# *City of Albuquerque*

October 10, 2000

RE: GRADING & DRAINAGE PLAN FOR BOSQUE MONTANO SUBDIVISION  
(E12/D12)ENGINEER'S PLAN STAMP DATED SEPTEMBER 14, 2000,  
(DRAINAGE REPORT DATED 9/8/00) SUBMITTED FOR SITE DEVELOPMENT  
PLAN FOR BUILDING PERMIT/SUBDIVISION APPROVAL.

ENGINEER'S SEAL	BOSQUE MONTANO	DRAWN BY JDN
GRADING AND DRAINAGE PLAN	DEC 11 2001	DATE 02-02-01
TERRA WEST, LLC	8508 JEFFERSON NE	3041GR.DWG
ALBUQUERQUE, NEW MEXICO 87113	(505)958-3100	SHEET 4 OF 17
RONALD R. BOHANNON	P.E. #7868	JOB # 200041

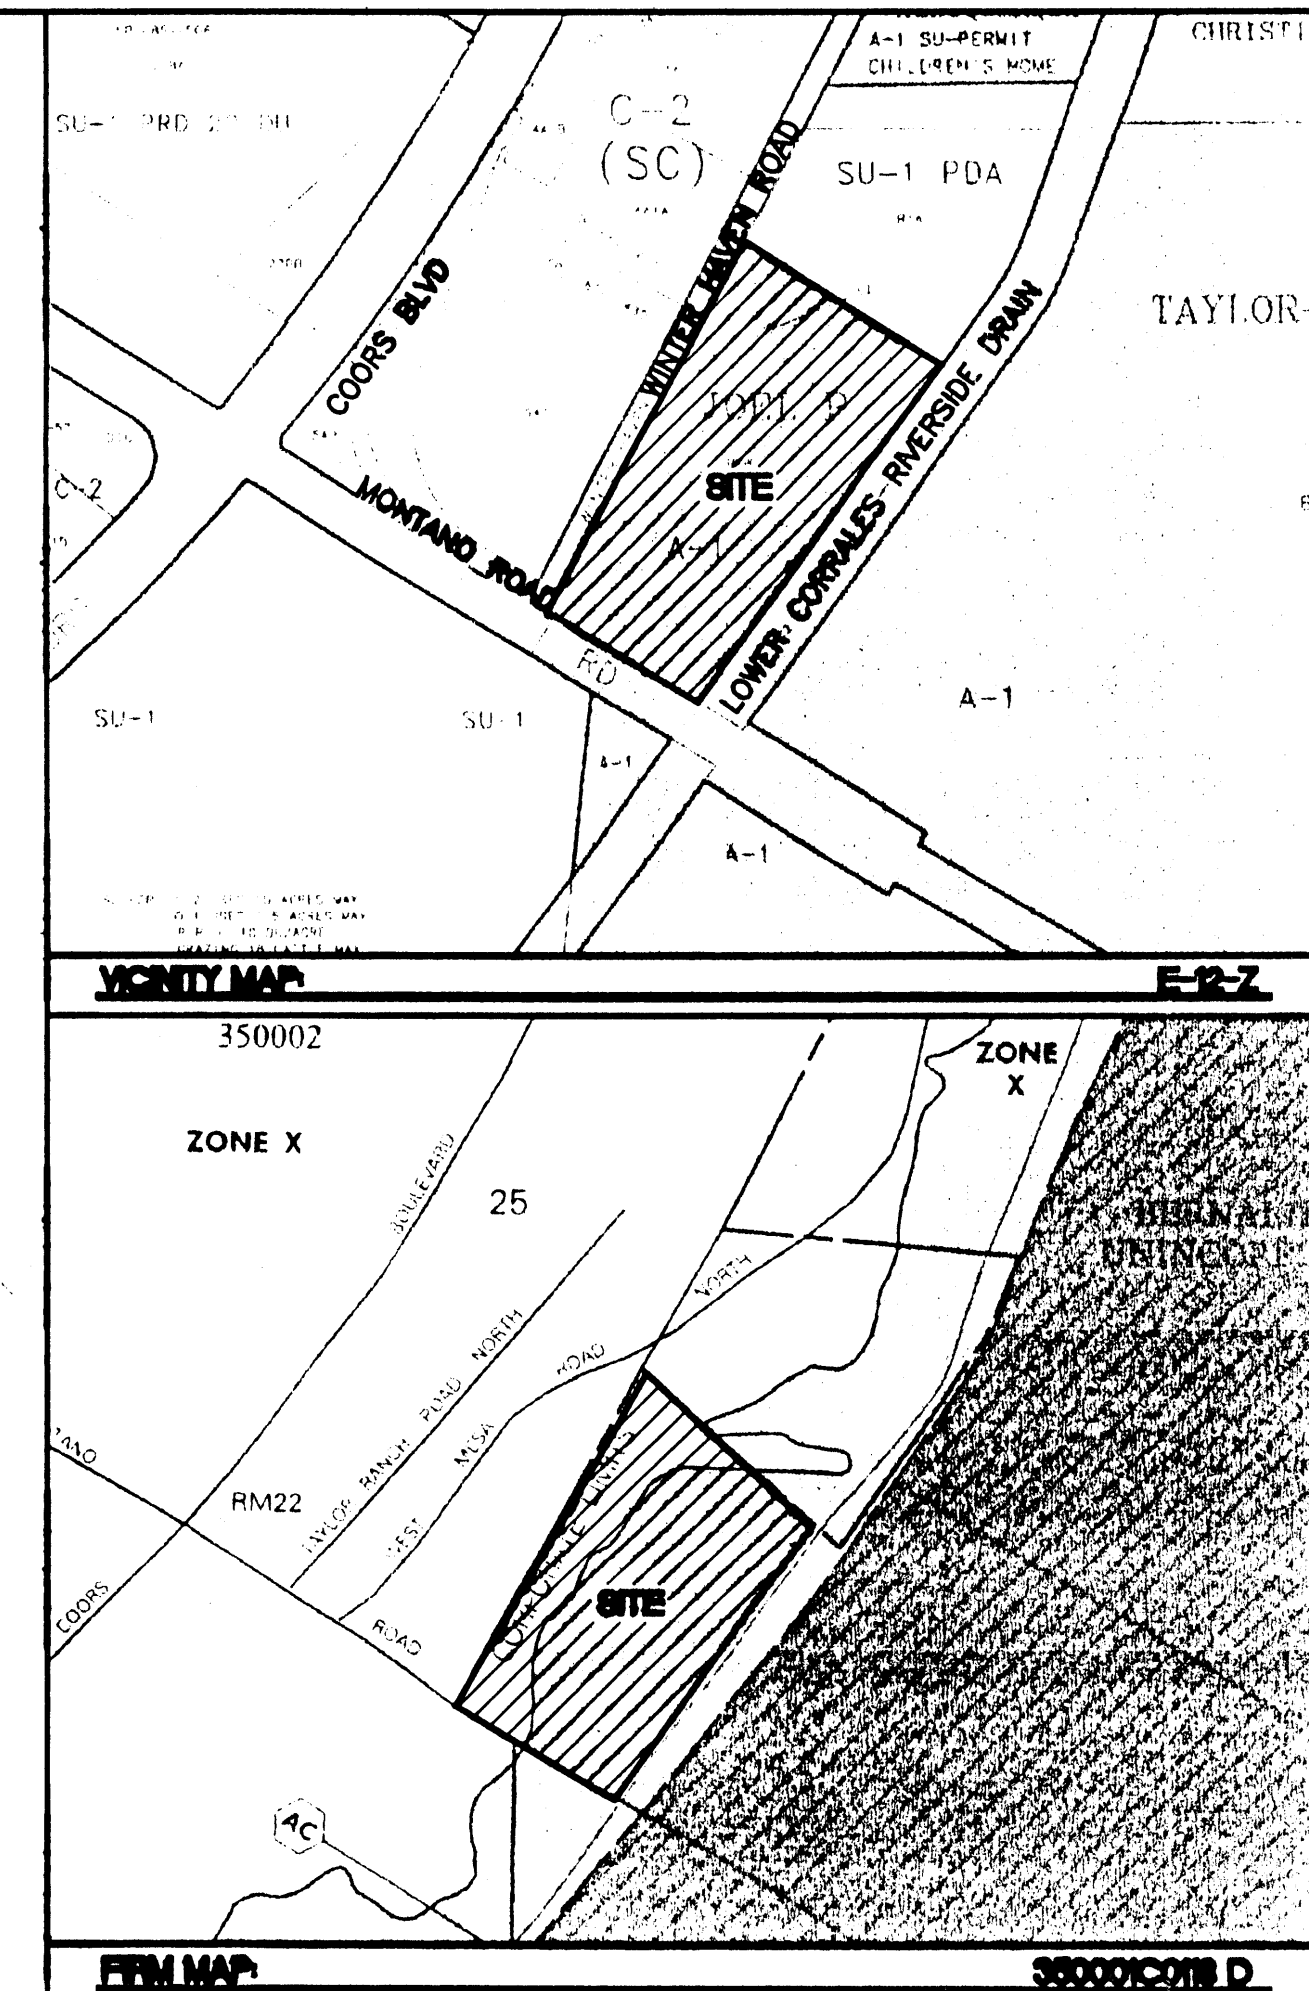
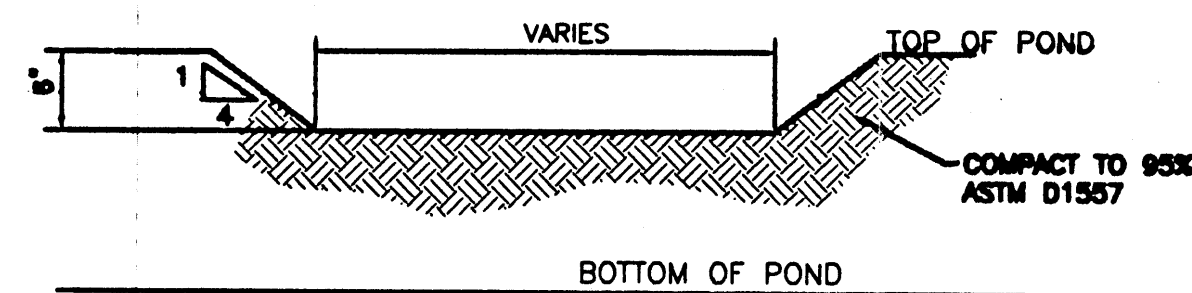
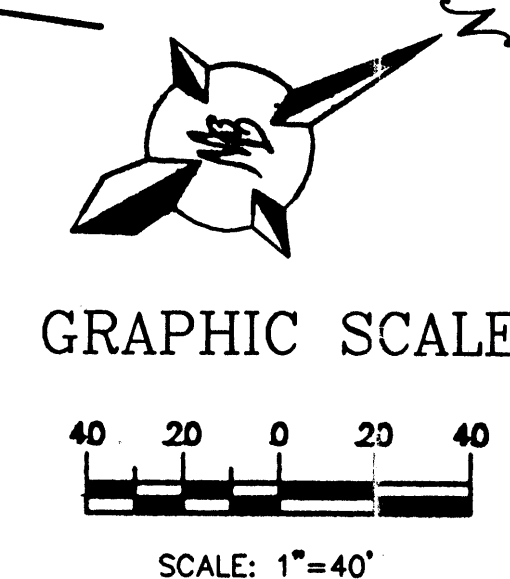
1. Provide details for pathways used for drainage.
2. Provide slope protection details for curb rundowns.
3. Provide additional details for pathways and driveway access at Winterhaven Road to insure containment of Winterhaven Rd. drainage.
4. Provide cross-sections for slope/retaining wall along Montano Road.
5. Provide details for pond emergency overflows and obtain MRGCD approval of drainage weirs on Riverside Drain.
